DOC17/630538-02  
SSD 8344

**SSD 8344 – KELLYVILLE NORTH PUBLIC SCHOOL – RESPONSE TO SUBMISSIONS (RtS) REPORT**

## **EPA comments on the Response to Submission Report for Kellyville North Public School SSD8344**

TITLE: **Remediation Areas**
Proposed New Primary School
120 - 126 Hezlett Road, North Kellyville

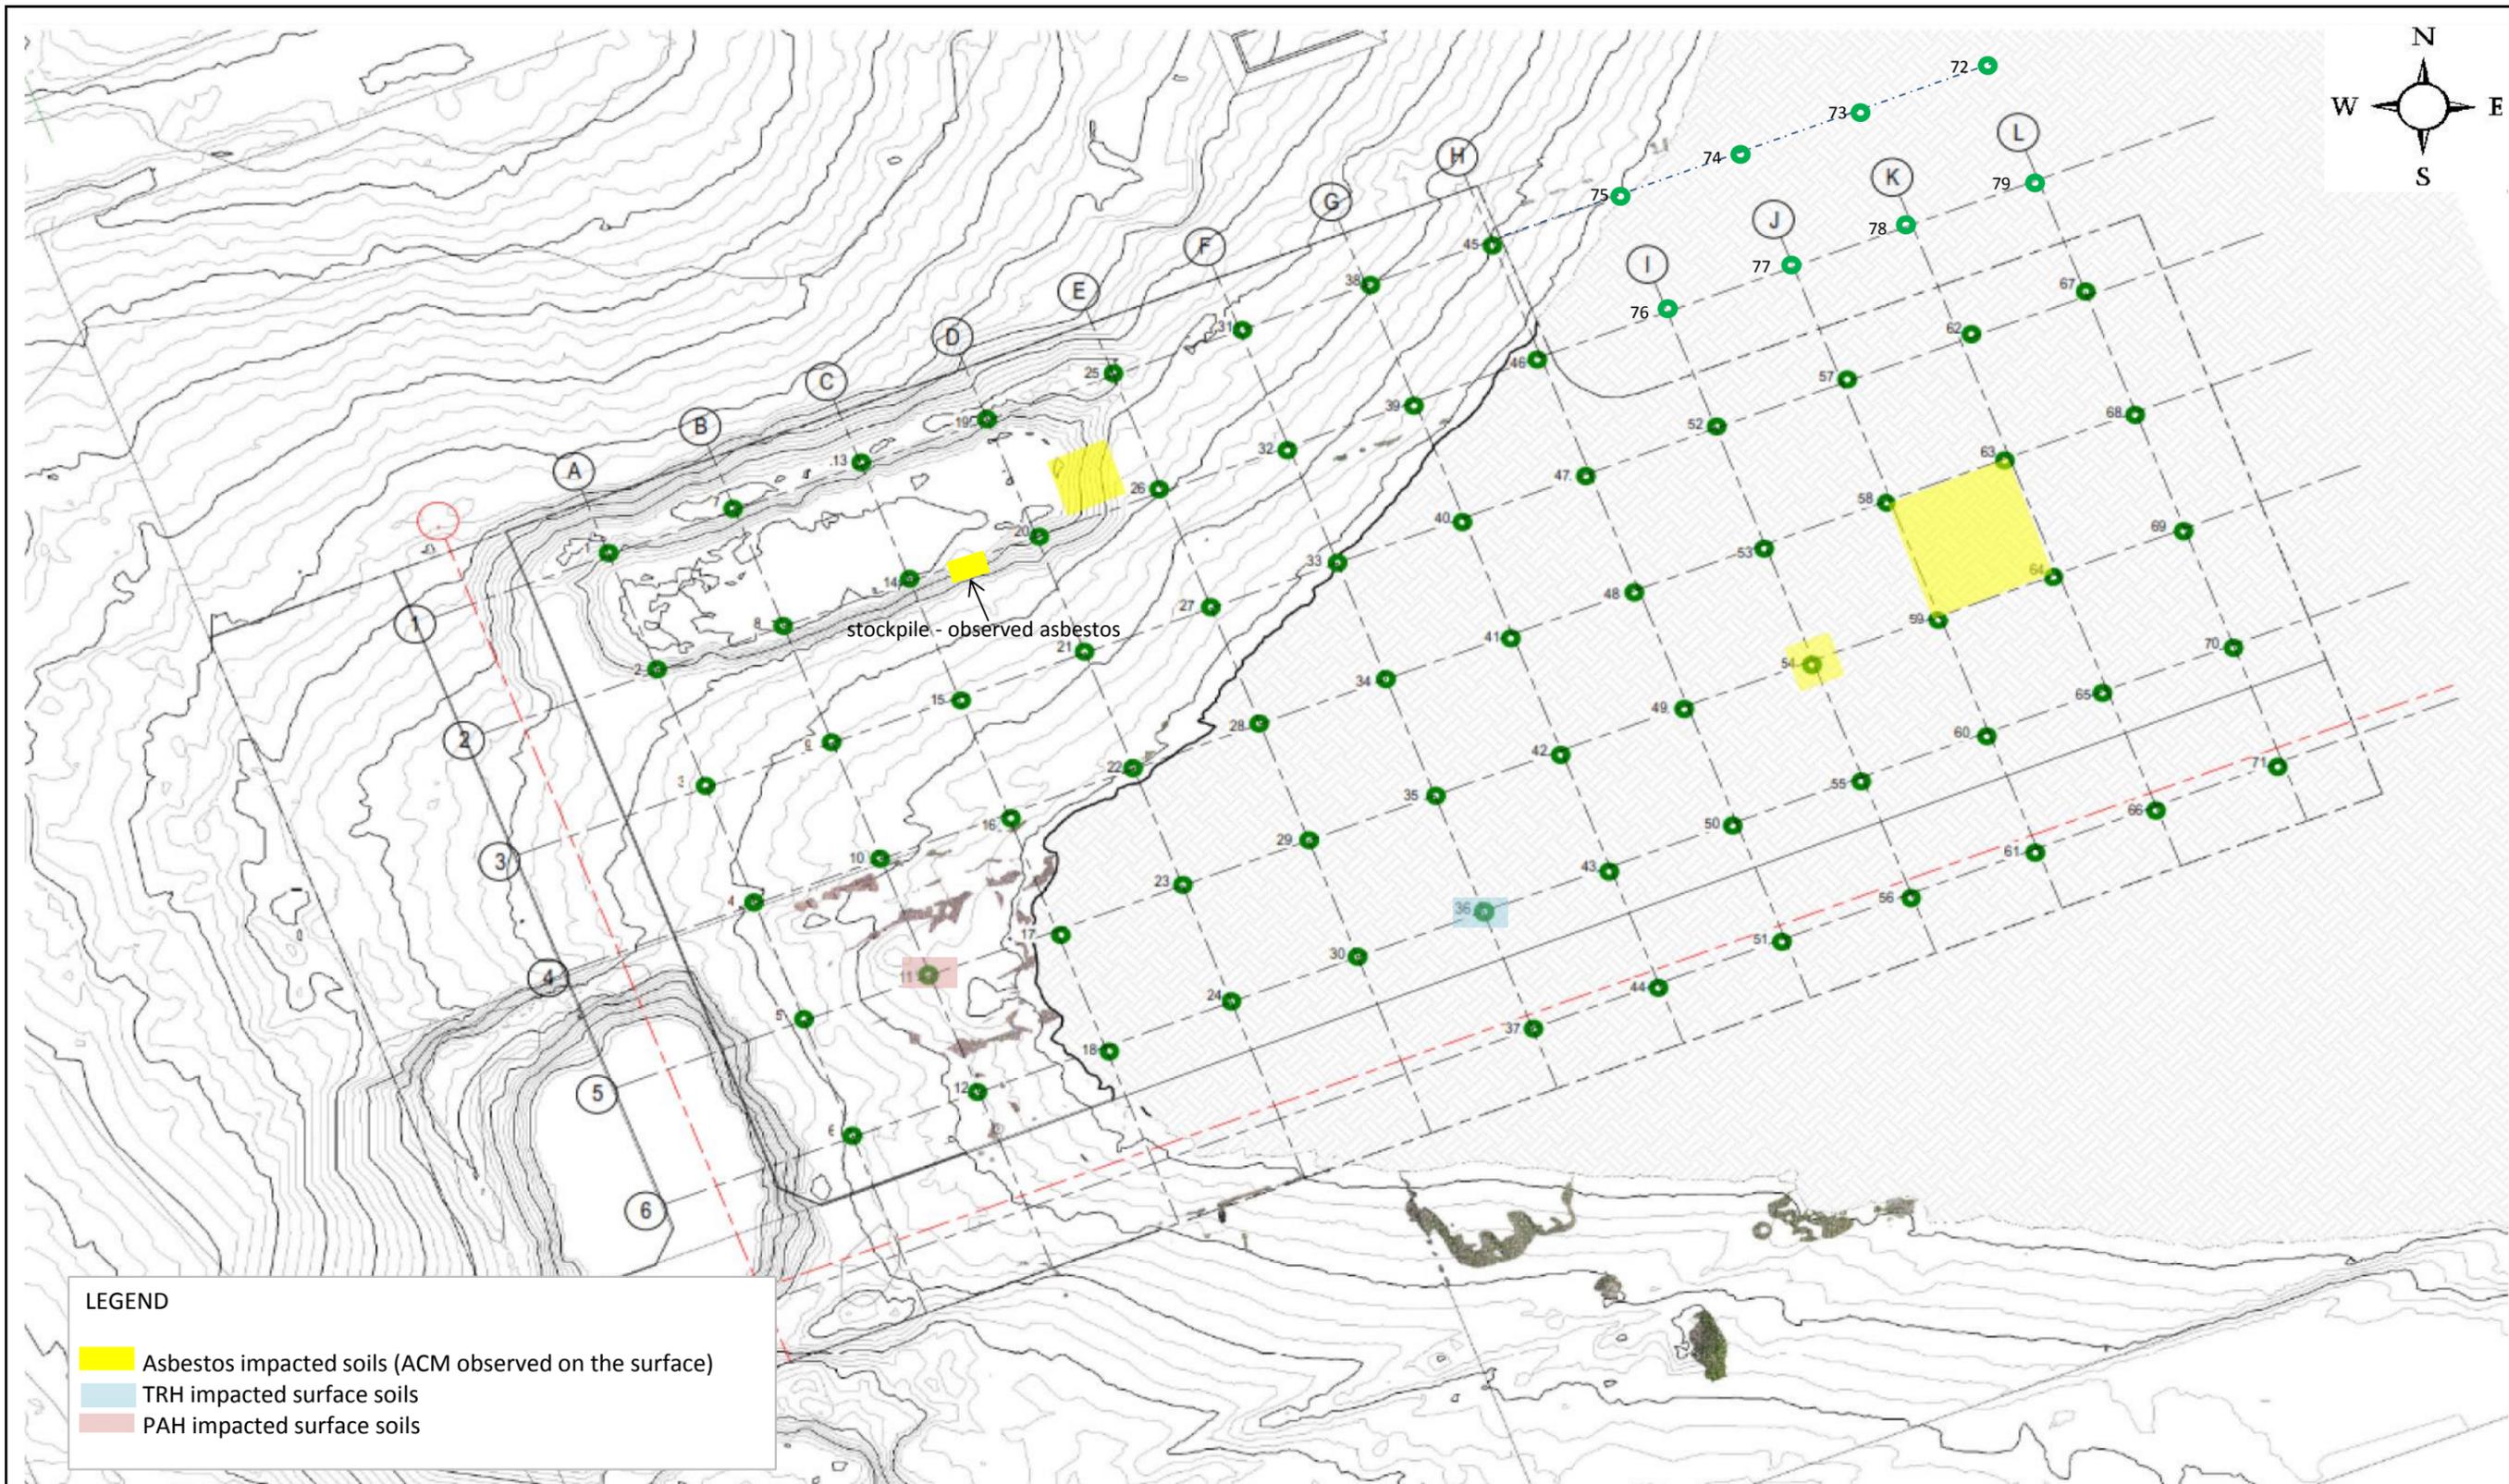
Section 8.1.4 to Appendix D to the Report inappropriately uses the term 're-use' in regard to the excavation, placement and cover of asbestos impacted soils beneath a physical barrier.

However, clause 81 to the Protection of the Environment Operations (Waste) Regulation 2014 states that *"a person must not cause or permit asbestos waste in any form to be re-used or recycled."* Whilst, the EPA does not consider the excavation, placement and cover of asbestos impacted soils beneath a physical barrier constitutes 're-use' (for the avoidance of doubt) that term should not be applied to the proposed remediation method.

Nevertheless, the EPA favours removal of asbestos impacted soils from sites proposed to be used for schools in preference to the proposed on site containment of those soils.

Should the proposed on-site containment of asbestos contaminated soils be approved, the EPA recommends that:

- (a) a long term environmental management plan is developed and used to identify the location and the requirements for ongoing management of asbestos impacted soil and other contaminated soil to be contained on the site;
- (b) an asbestos works management plan with stringent requirements for dust and water should be prepared and implemented upon confirmation from the auditor that the asbestos works management plan is considered to be appropriate.
- (c) all services lie above the marker layer to minimise any risks to workers undertaking future maintenance work in service trenches;
